Traffic Impact Study
(LSC #184560)
October 18, 2019
Add PCD File No. CR191

Please title this as a
Master Traffic Impact
Study
Falcon Field
Traffic Impact

Figure 2
Conceptual Site Plan
Falcon Fields (LSC# 184560)

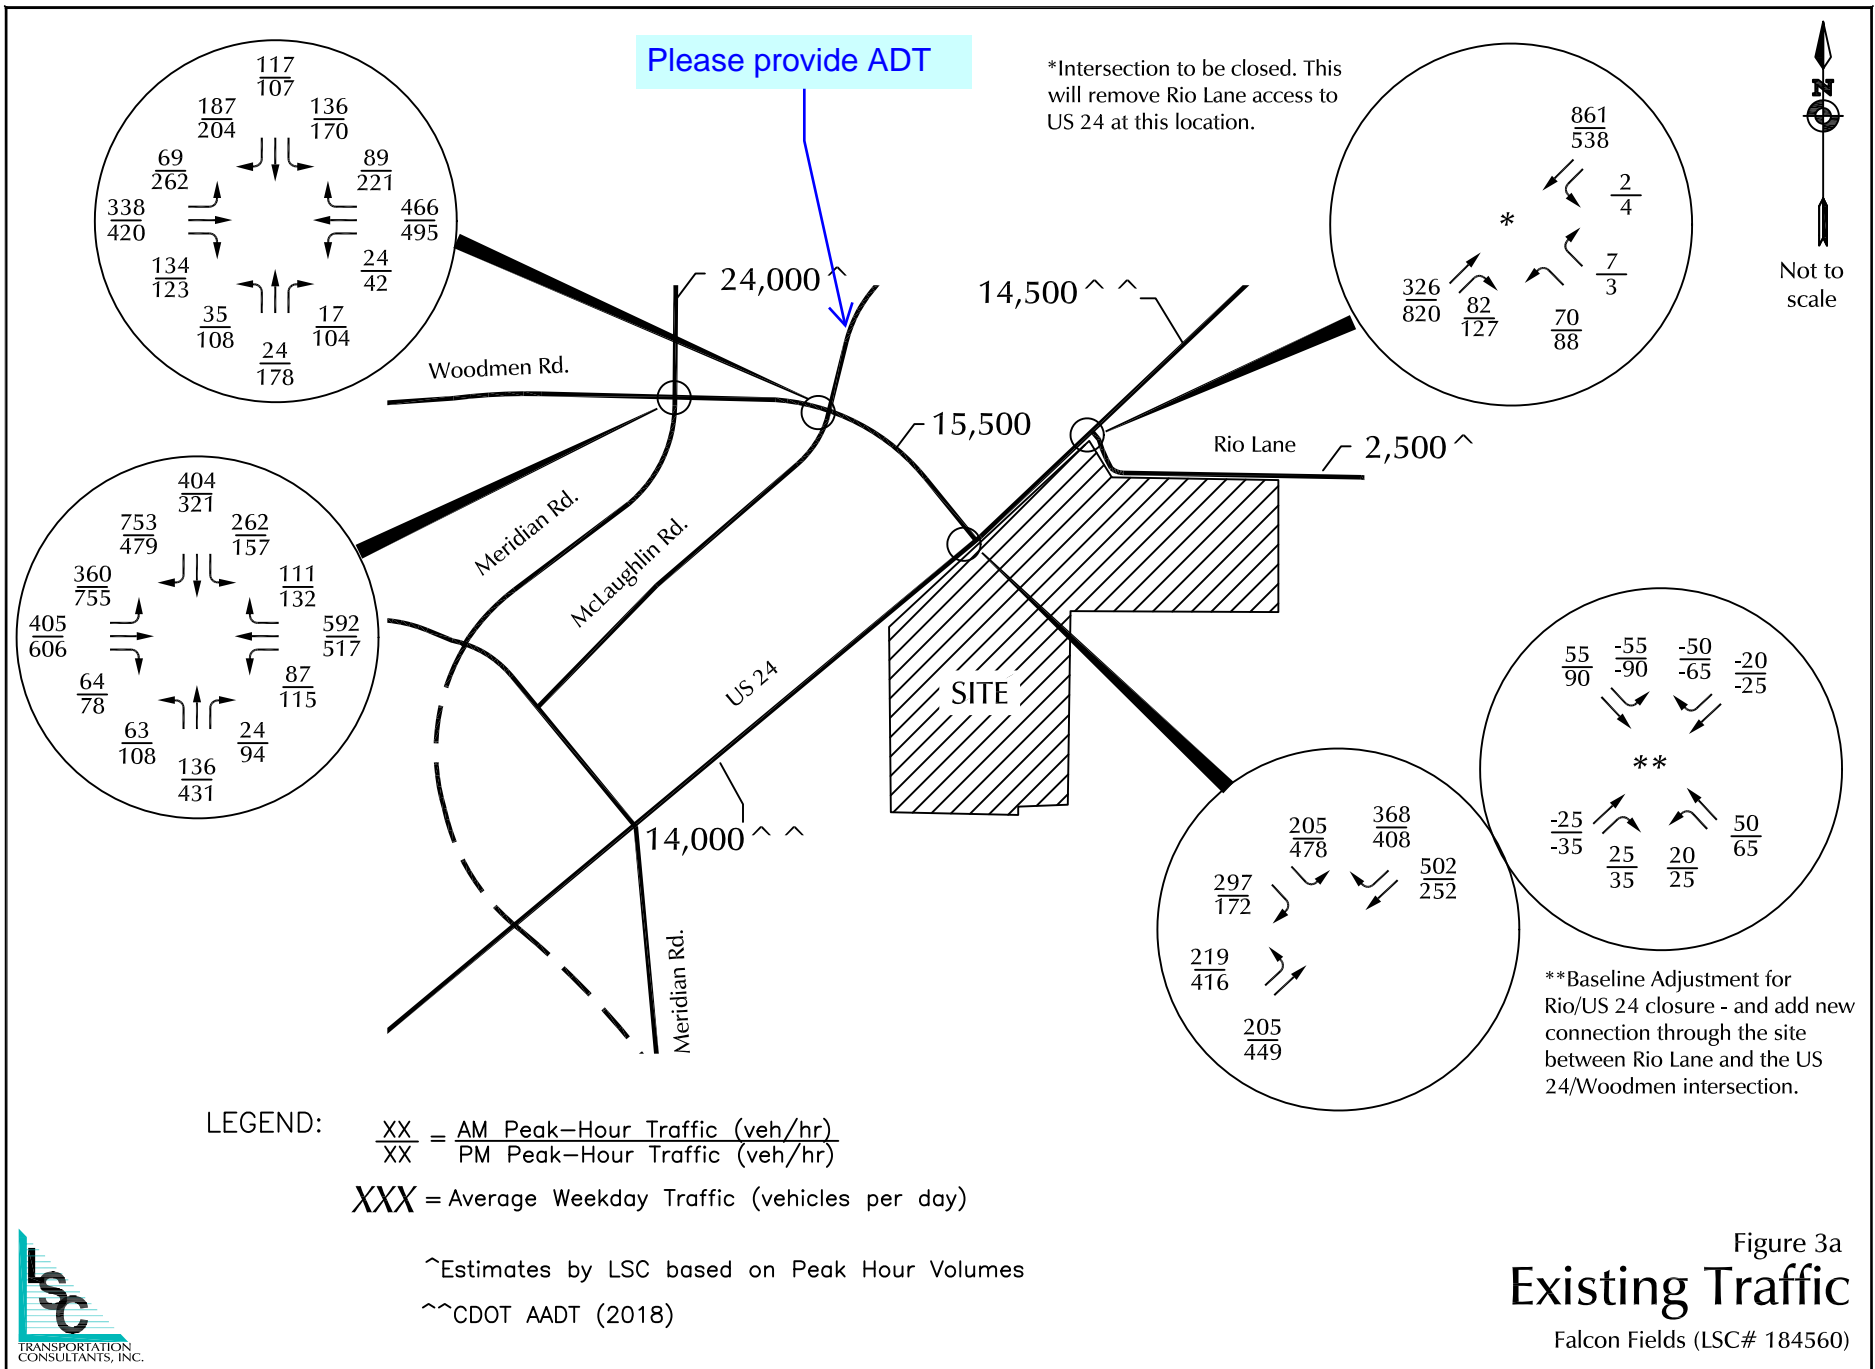
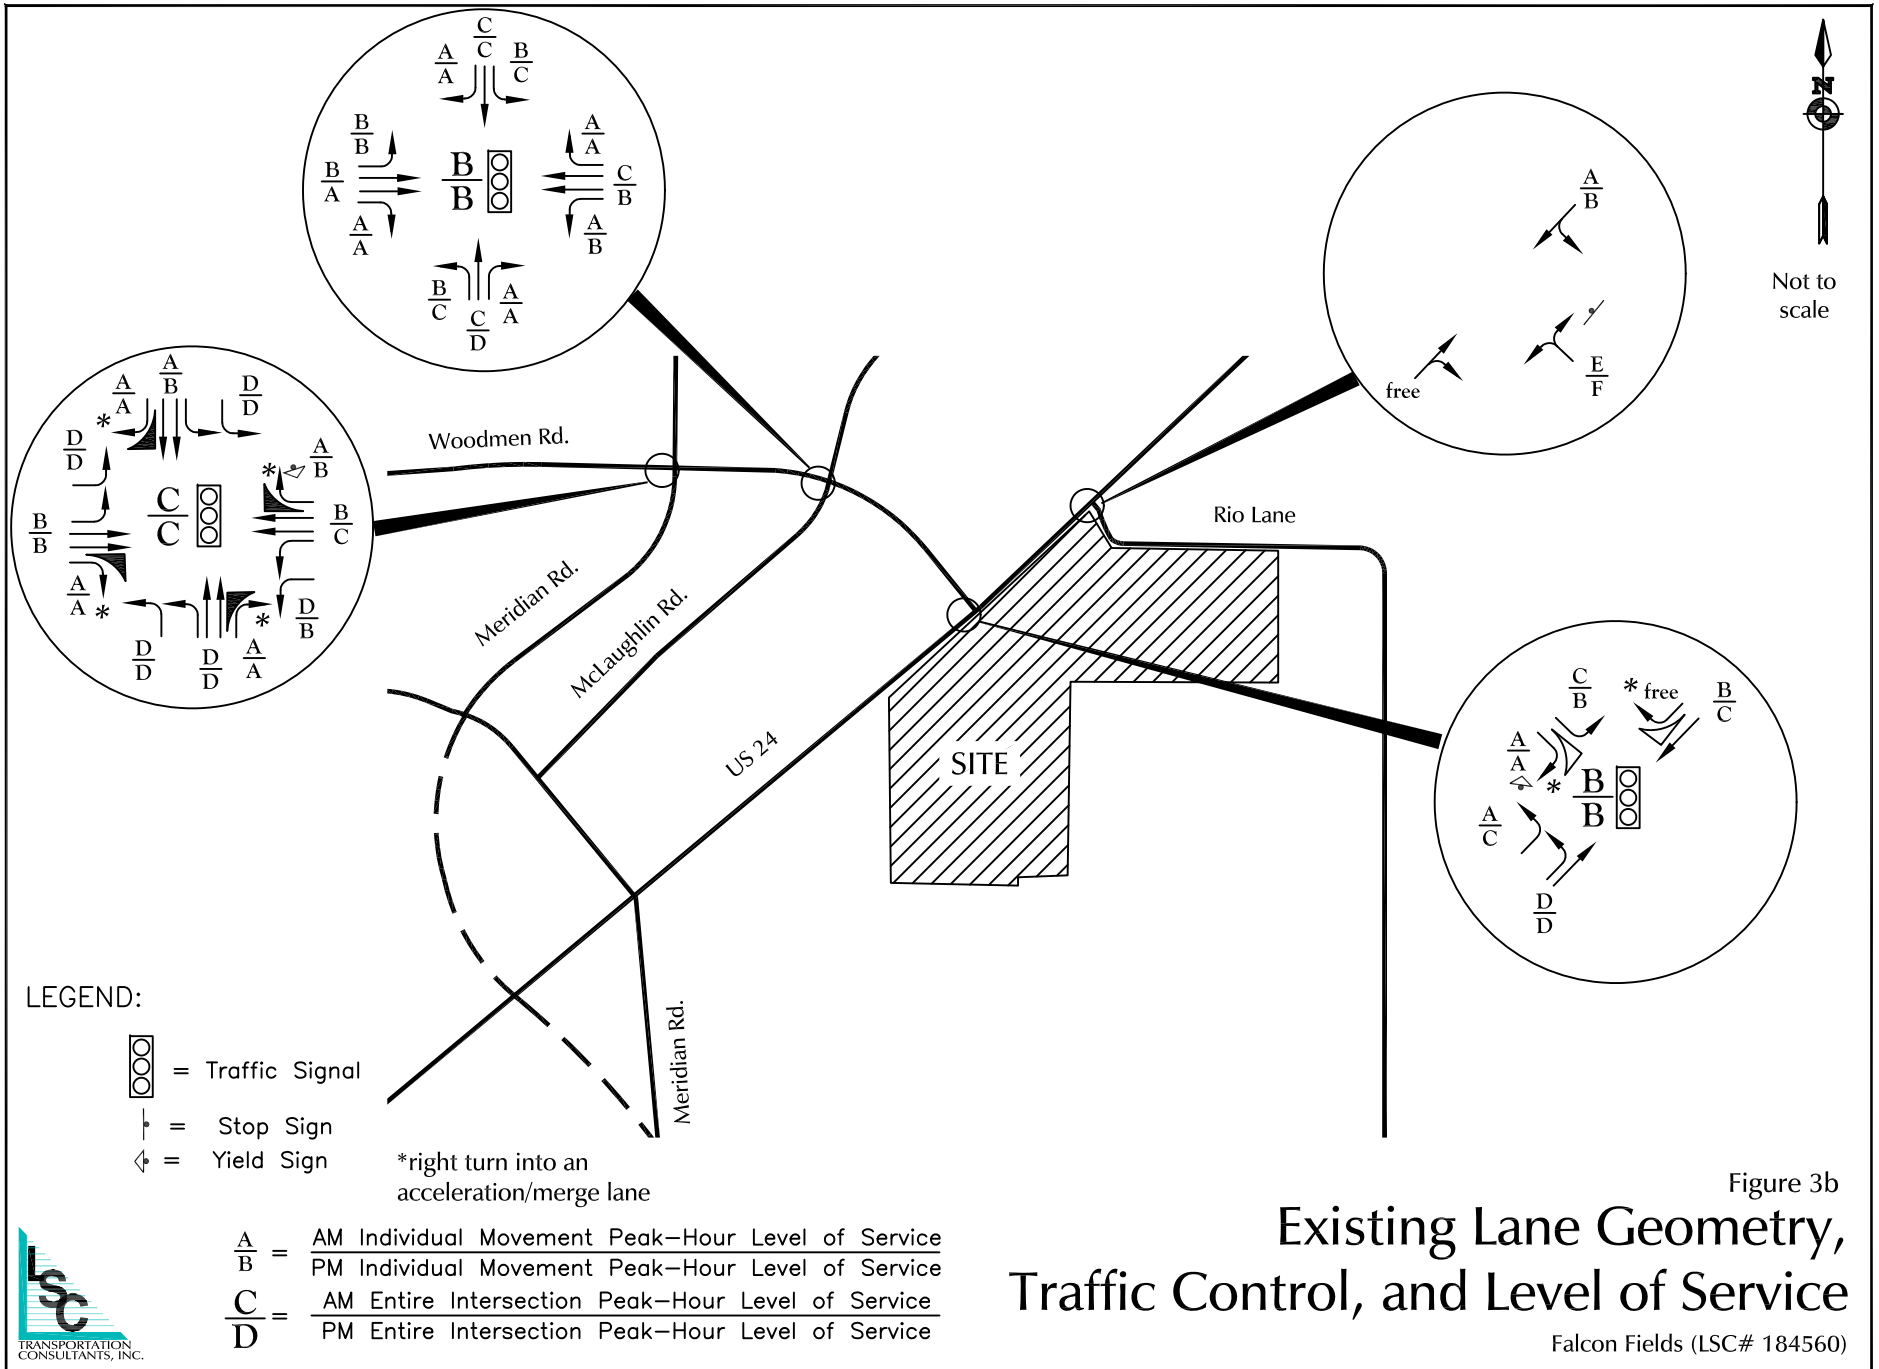
The conceptual site plan also show additional
roads that would connect to the west in the future.
Please include these in your narrative and also
indicate the anticipated classification of these
roads.

The conceptual site plan also shows storage units. Please include this in your trip generation estimate.

Figure 4

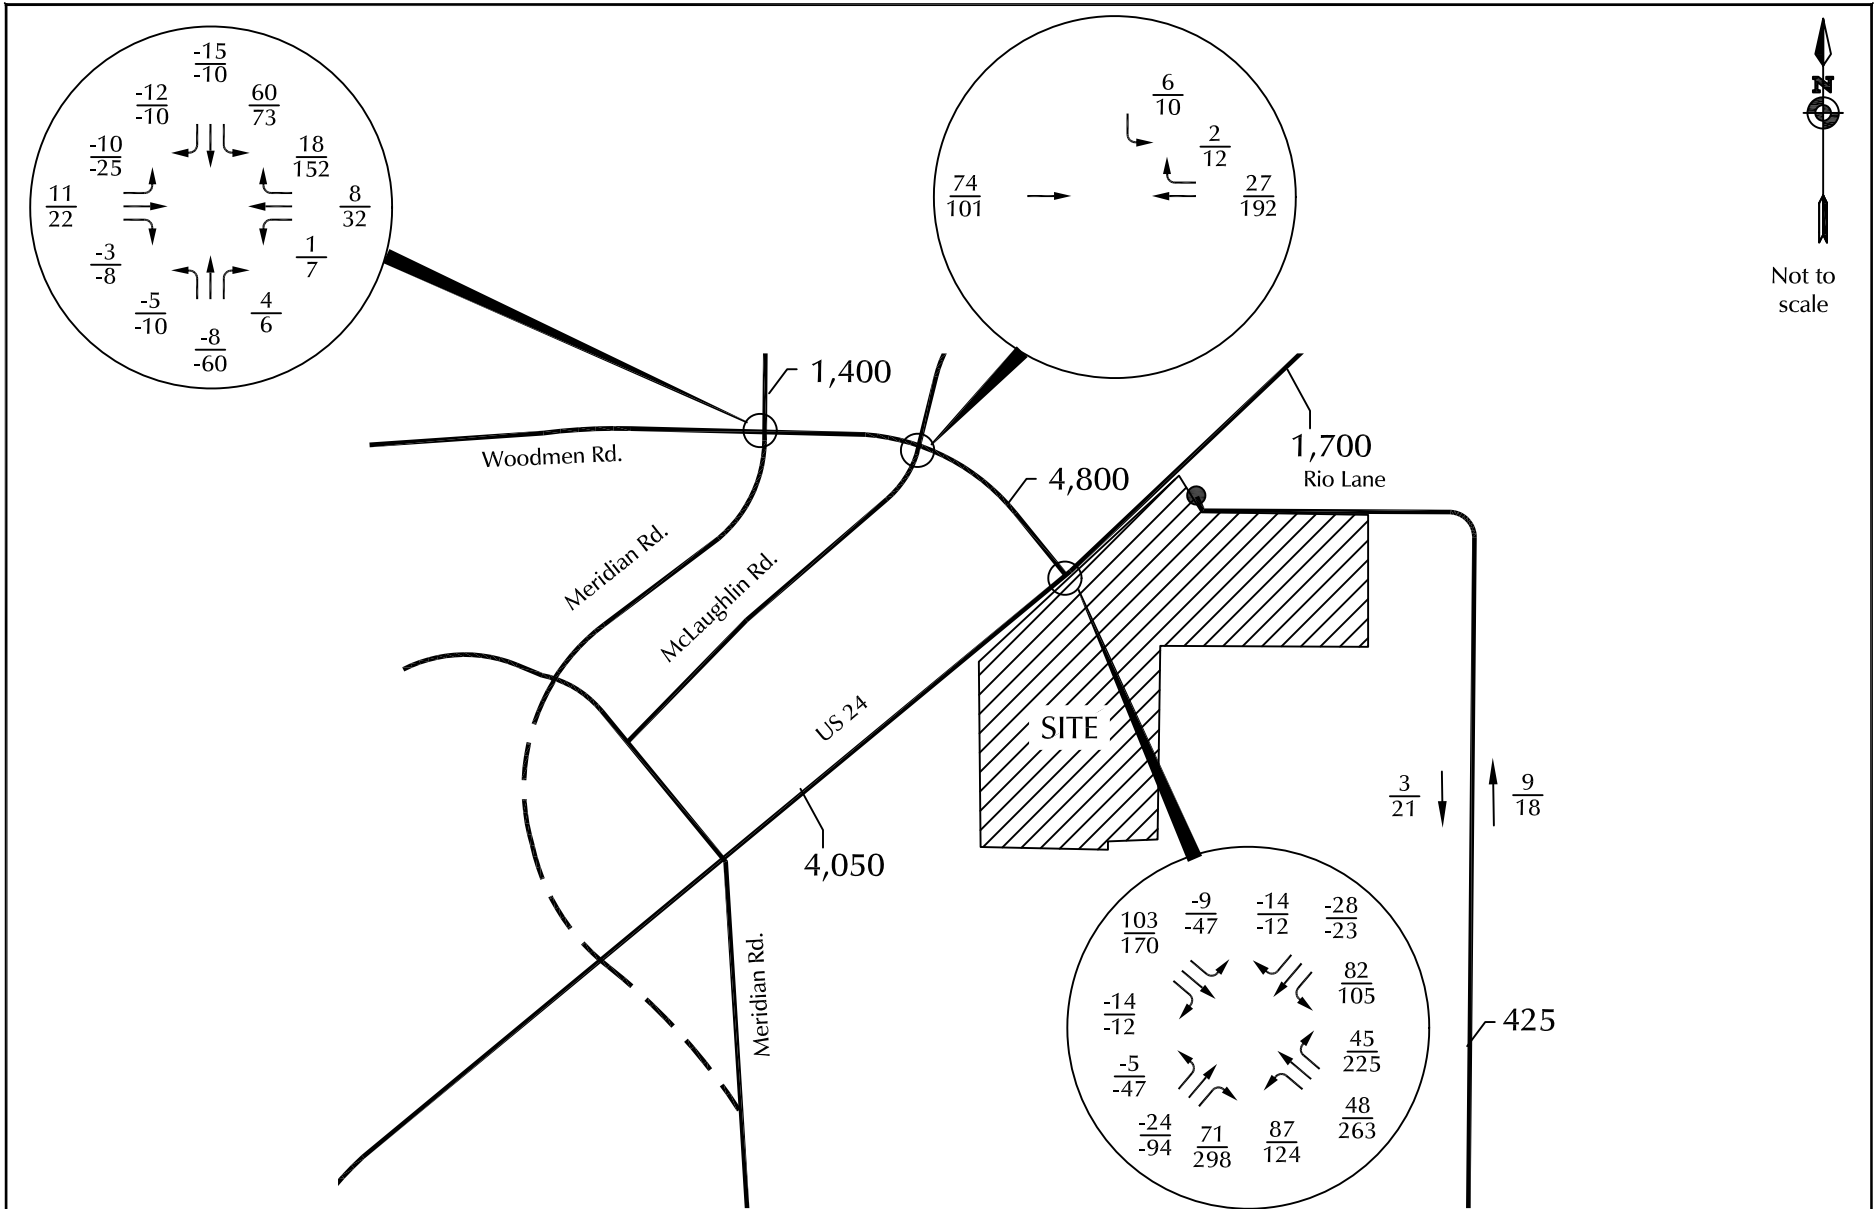
Please also include in the narrative the other distribution estimates shown in figure 4 with your reasoning for the estimates. Also see comment on figure 4.

McLaughlin Rd connects to Eastonville Rd. I believe this should be a larger percentage as both woodmen hills and meridian ranch subdivisions access Eastonville. Per the existing traffic provided it appears that the amount of traffic on McLaughlin is almost half of what is on Meridian. I would expect that the distribution would be similar (i.e. 28% and approx. 14%) and with a lower distribution on HWY 24.

Provide percentages for Rio Lane
